**Consultation Response from KC,  
Lead Local Flood Authority**

**2026/90108 Land off, Blackmoorfoot Road and Felks Stile Road, Crosland Moor, Huddersfield,  
HD4 7AD**

**Discharge of details reserved by condition 8 (temporary drainage) on previous permission 2024/92235 for reserved matters application (including consideration of appearance, scale, layout, access (including pedestrian and cycle access into and within the site and vehicular access within the site)) and landscaping) for the erection of 231 residential dwellings and associated works including landscaping and the provision of open space pursuant to [WESTERN PARCEL of] permission 2024/92614 for variation and removal of conditions 4 (access works), 8 (Blackmoorfoot Road improvements), 10 (junction details), 16 (retaining wall design), 17 (highway structure design), 18 (surface water drainage strategy), 37 (external lighting strategy), 39 (crime mitigation measures) on previous outline permission 2020/92546 (with details of points of access only) for development of up to 770 residential dwellings (Class C3), including up to 70 care apartments (Classes C2/C3) with doctors surgery of up to 350 sqm (Class D1); up to 500 sq

Client		MILLER HOMES	
Drawing Status	PLANNING	Date	MAY 2026
Scale	1:500	Drawn by	WC
Project	HAWKSLEY PARK BLACKMOORFOOT ROAD HUDDERSFIELD	Check by	TB
Drawing Number	6910-WTWD-00-XX-DR-D-9402	Revision	P2
Drawing Title	POLLUTION PREVENTION PLAN PHASE 2

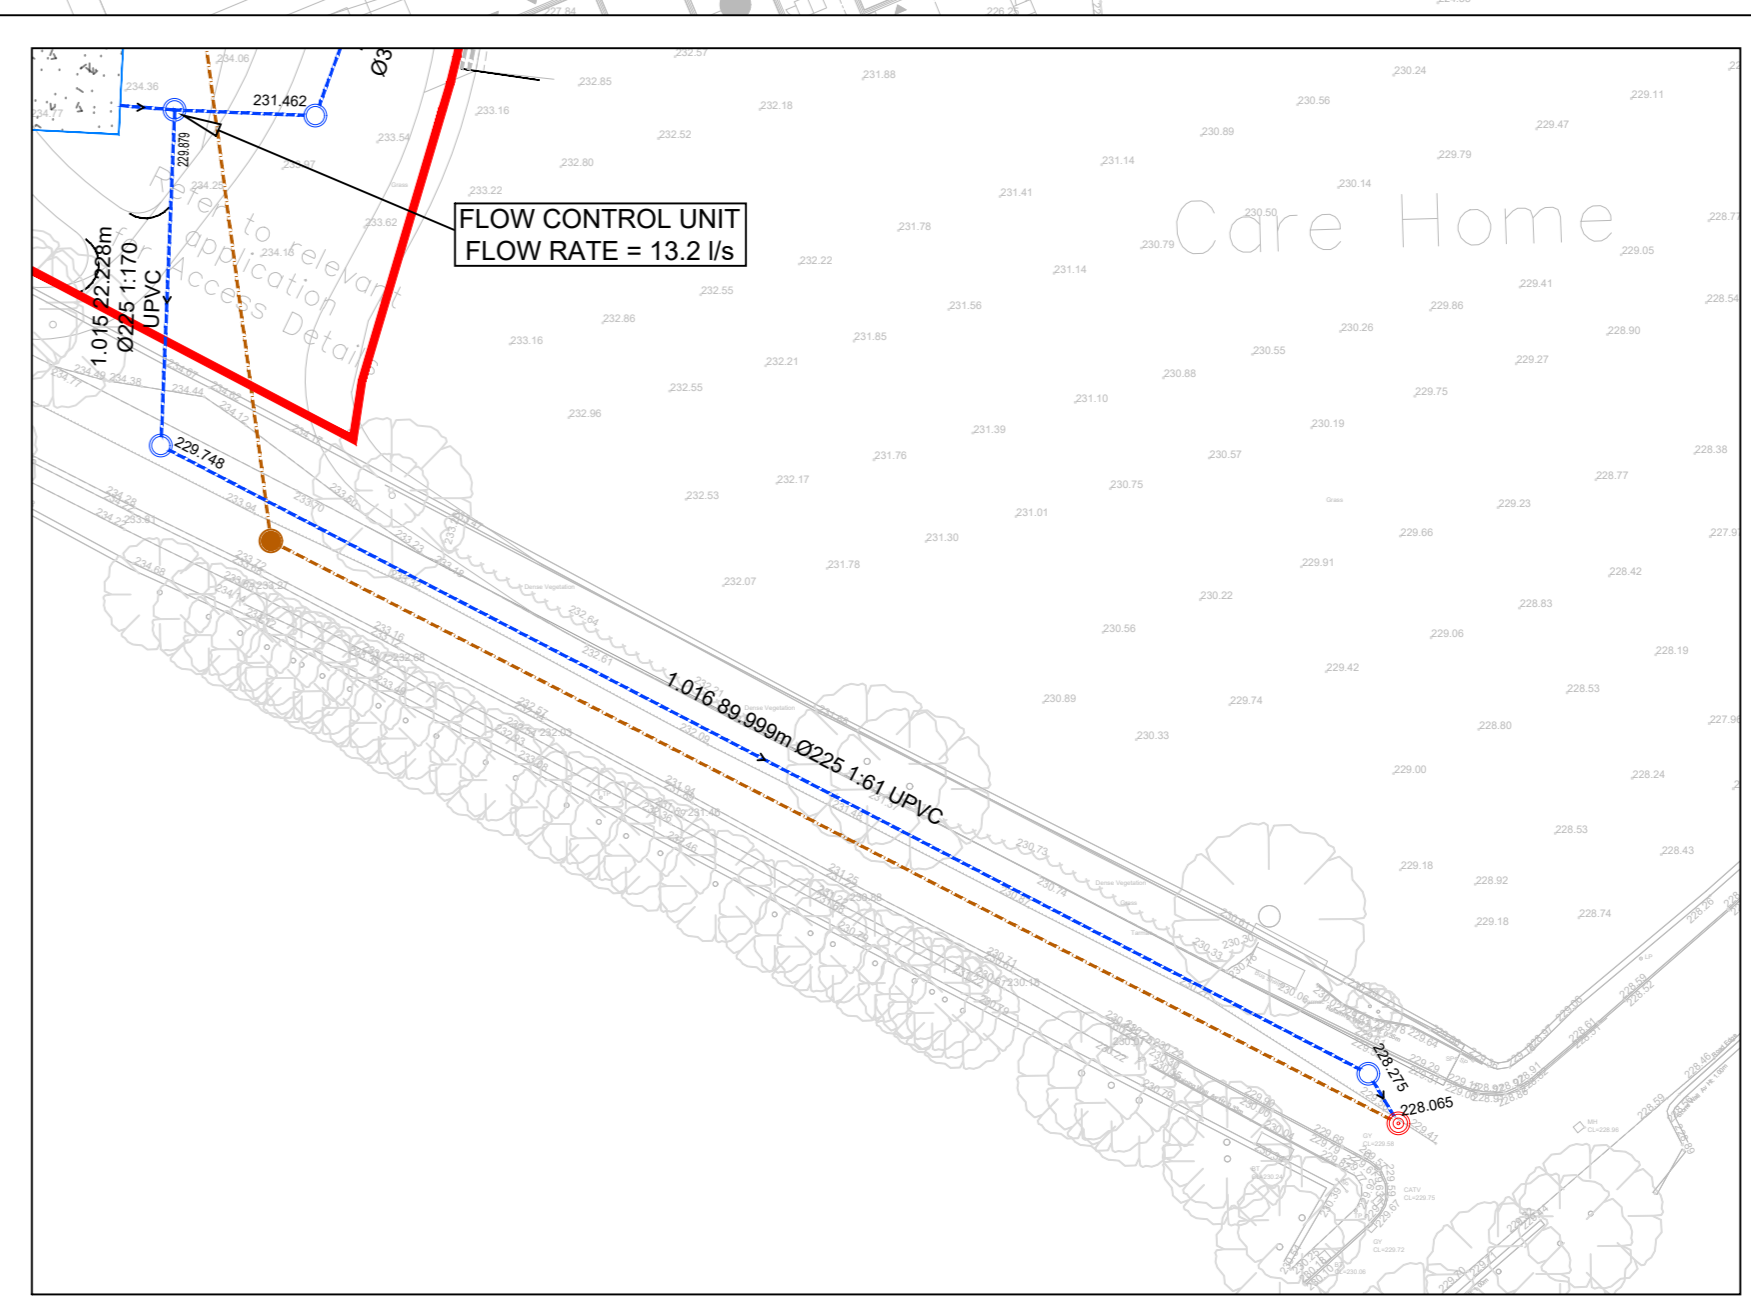
The plan provided (on its own) is too simplistic. It requires levels and directional arrows, and a site of this size should have this plan linked into a construction management plan with different phases.

We suggest that not all the site be stripped where practicable to prevent increased run off for early phases.

A narrative should be produced that presents a risk-based approach with source-pathway-receptor at its heart, i.e. a clear indication of where water will go during construction phases, what will be clean and contaminated (silted) water. This should look at storing the 1 in 2 6 hours storm for the developing site area and contain it on site as stated in the condition. Evidence of achieving this volume must be supplied.

Spoil heap location will be critical.

The risk of flooding to adjacent roads and siltation of local drainage networks are clear. Any mitigation in the narrative should have back up plans should the temporary drainage be overwhelmed. For example, tinkering/flocculation etc.
